Date: 20 February 2024
Our Ref: 24/00097/FULHH
Please ask for: Mrs Hannah Roper

Invalid Application

Proposal: Two storey side extension, rear dormer extension, adaptation of the roof from hip to gable, replacement front dormer, adaptation to the front garden wall and gates, following demolition of the existing garage.
Location: 46 Coppull Moor Lane Coppull Chorley PR7 5JH
Reference: 24/00097/FULHH

Drawing Title:  
BOUNDARY WALL

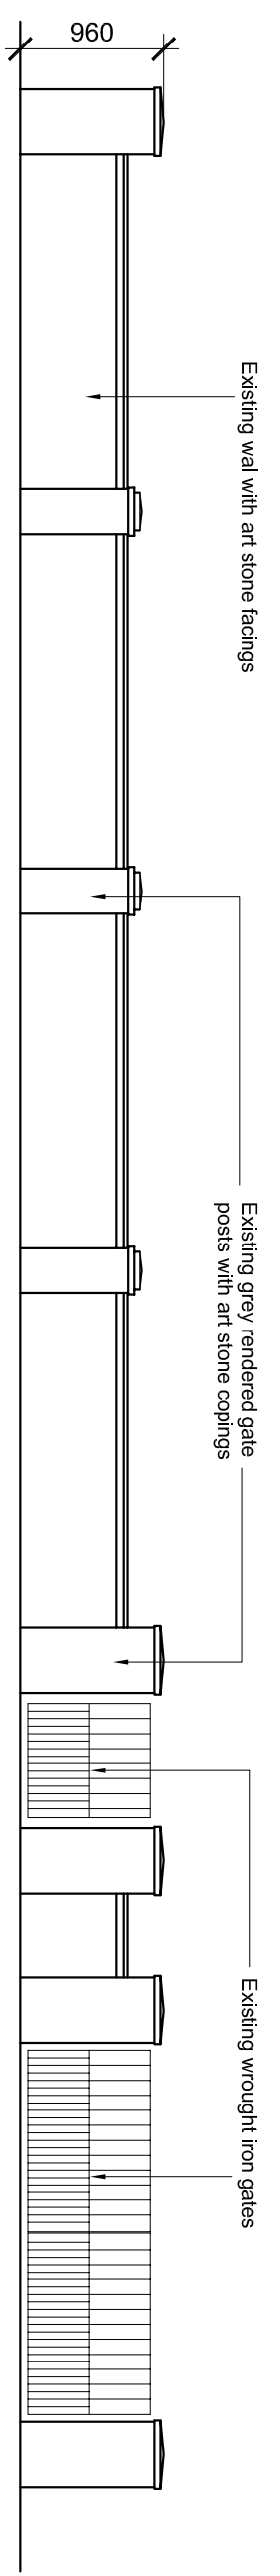
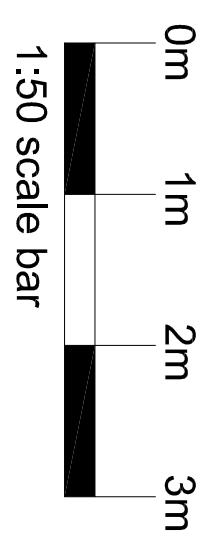
1. Red Line Location plan with two road names annotated.
2. Full elevational details of the existing and proposed front boundary treatments.
